Our Ref: BR/49/19/OUT

**Town & Country Planning Act 1990 (as amended)
Town & country Planning (Development Management Procedure) (England) Order 2015 - Article
5
Application for Outline Consent**

Development Outline application with all matters reserved for 22 No. new dwellings consisting of 2 No. 1 bed dwellings, 18 No. 2 bed dwellings & 2 No. 3 bed dwellings.
Location 26 Burnham Avenue Bognor Regis

Second Floor Plan (Proposed) 1:100
2 x 2 bed Flats & 1 x 3 Bed Flats
x 2 Blocks

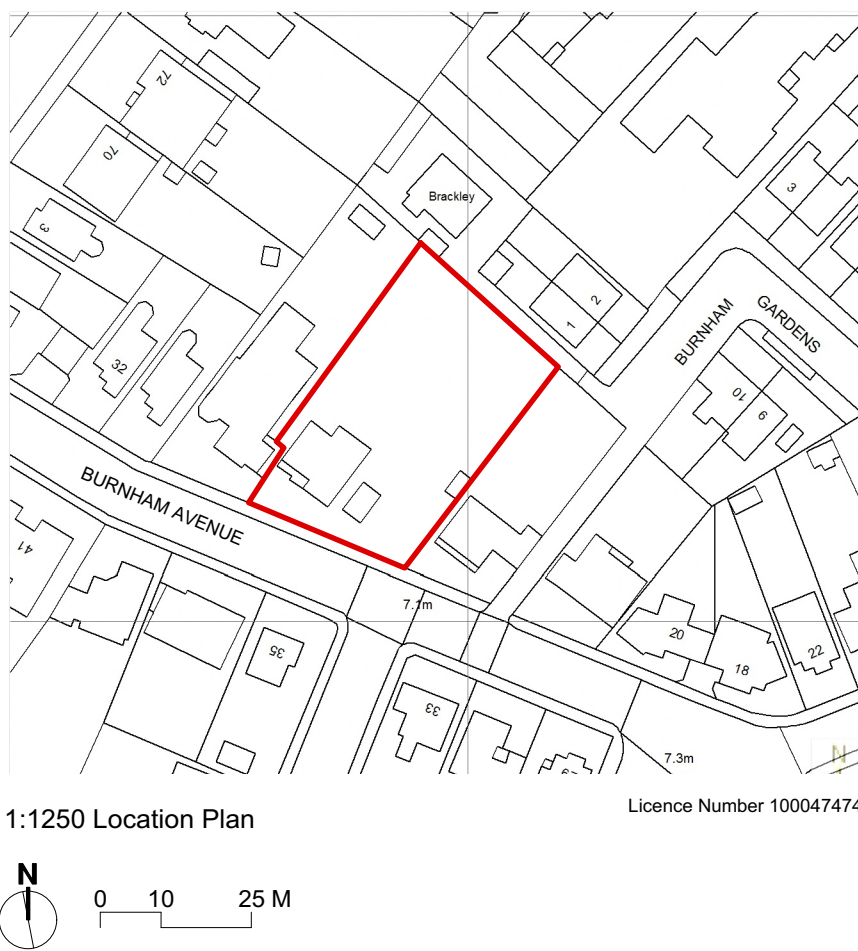
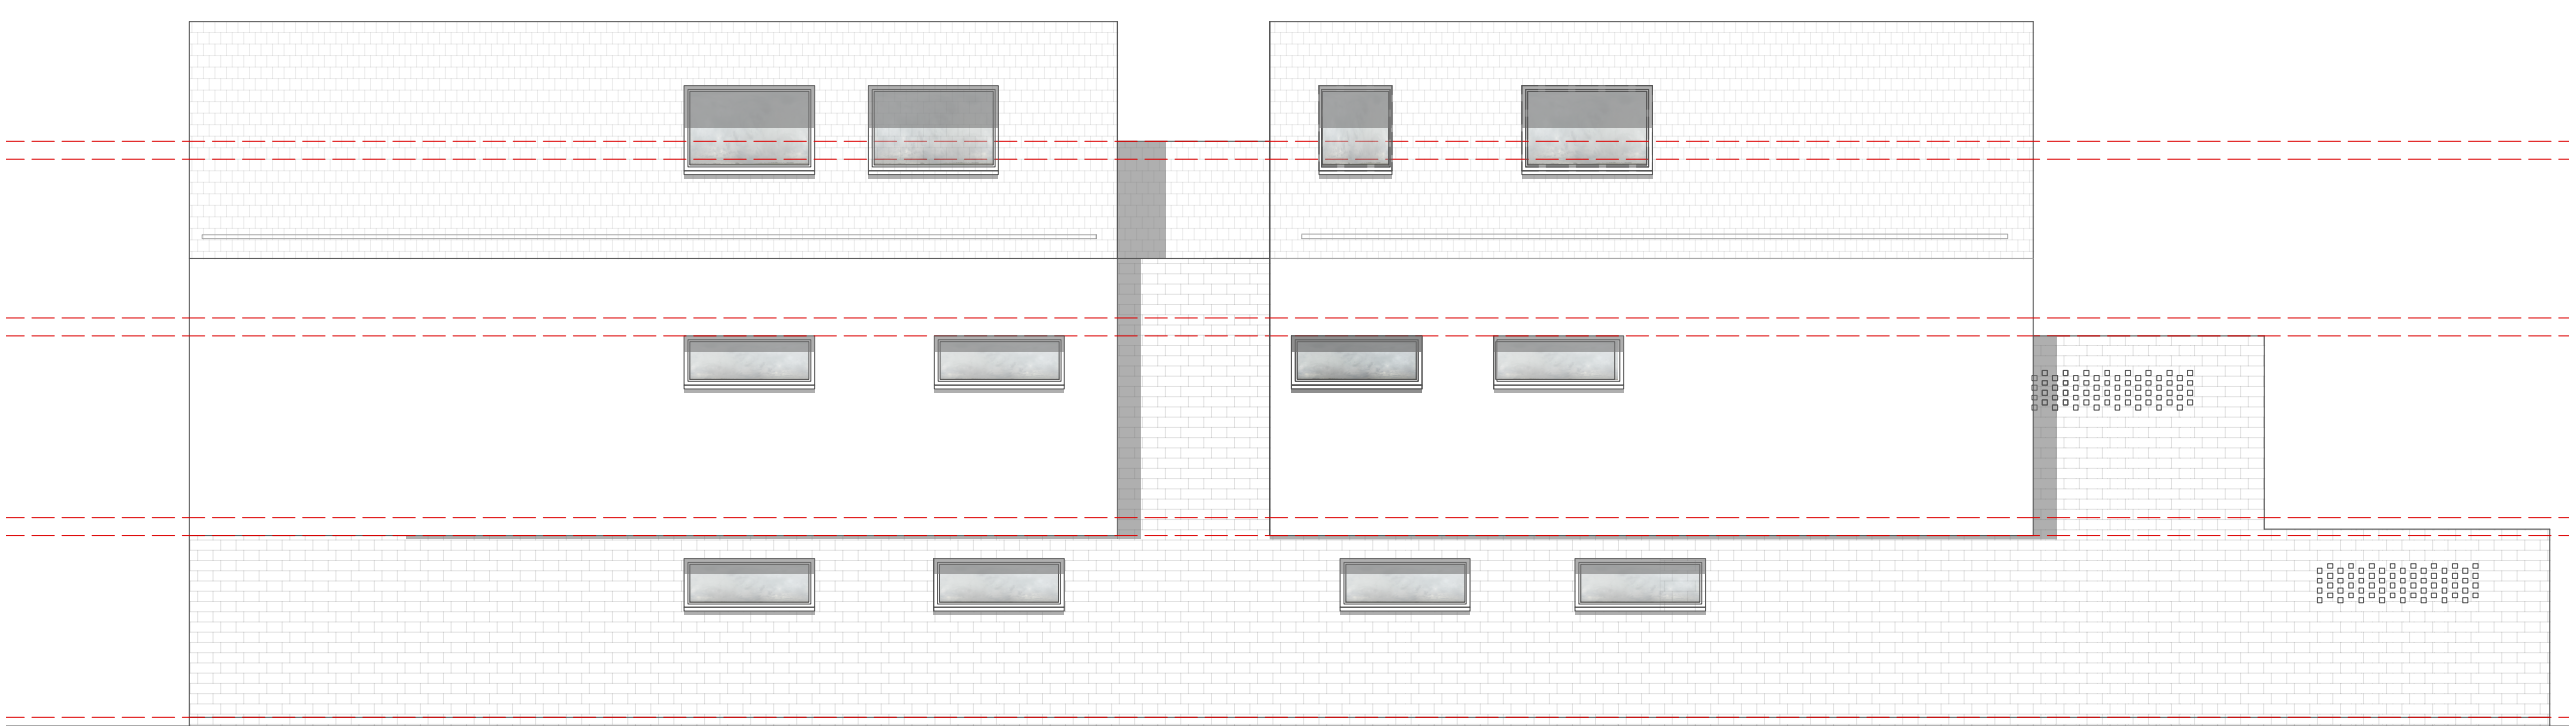
The second floor plans and east and west elevations do not accord on Blocks A & B. Please amend accordingly.

Roof / Site Plan (Proposed) 1:200

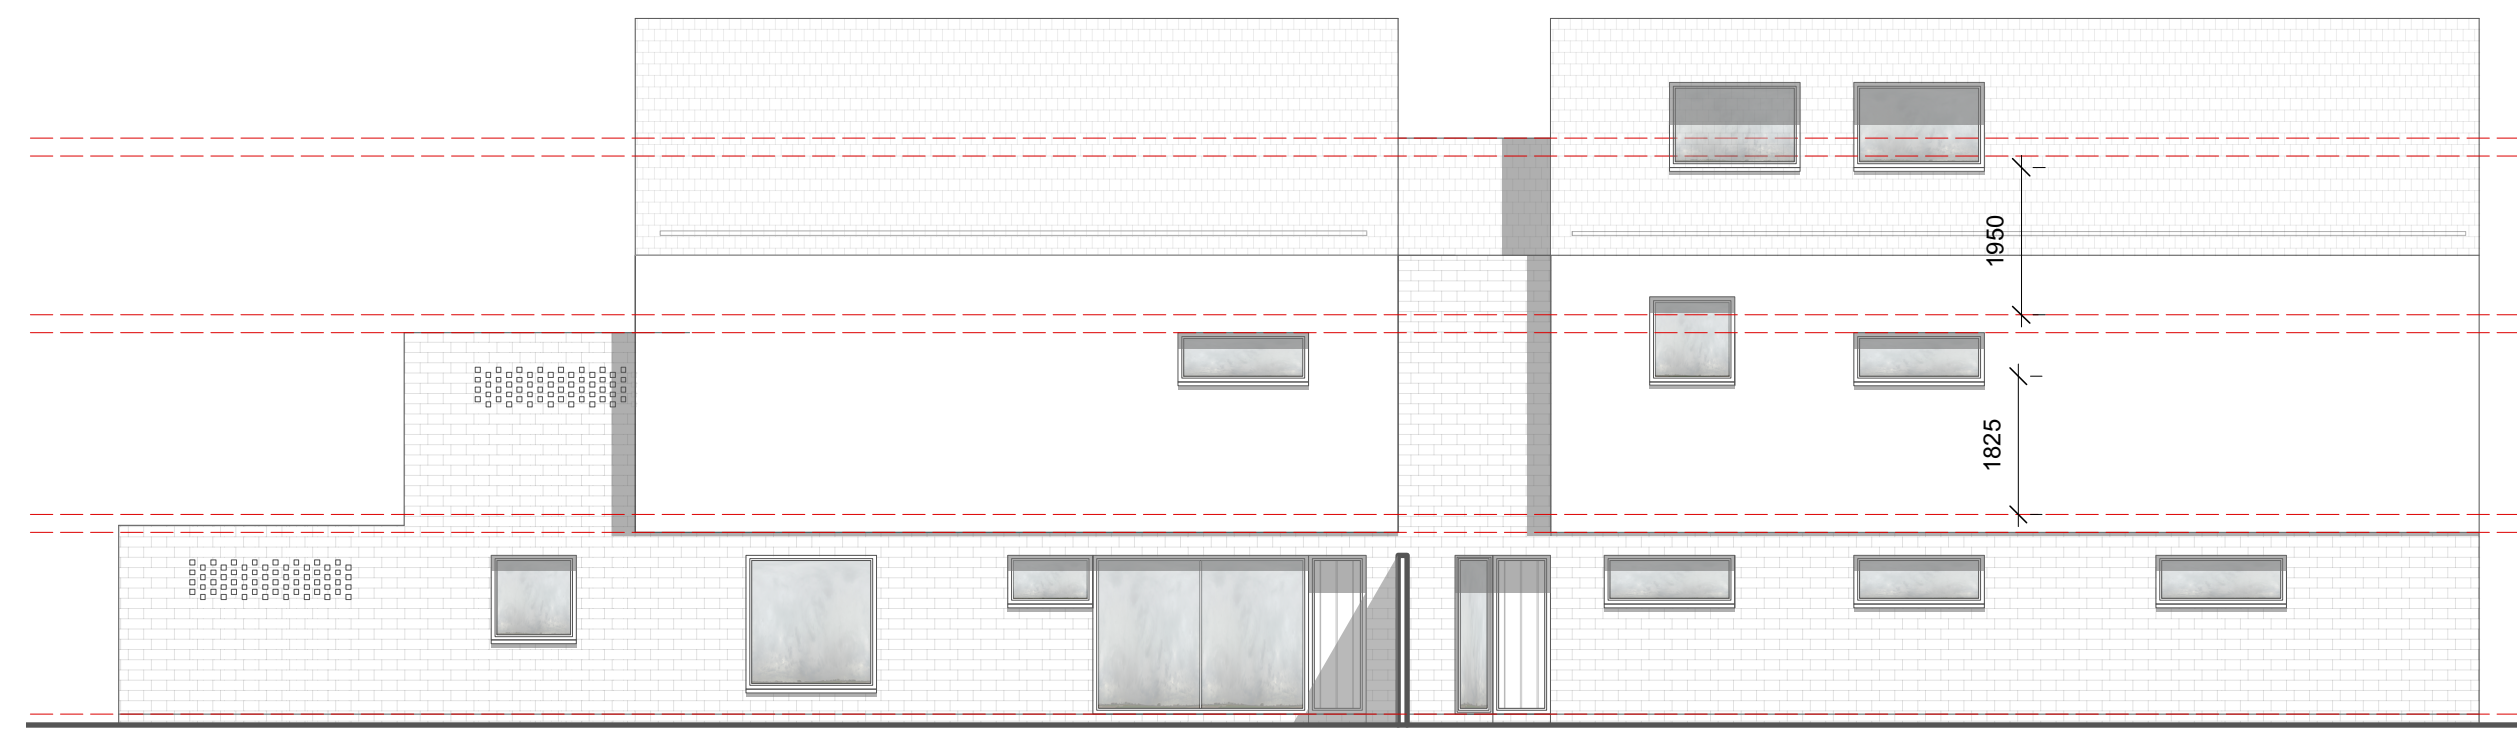
On the proposed roof/site plan, please clearly show the access.
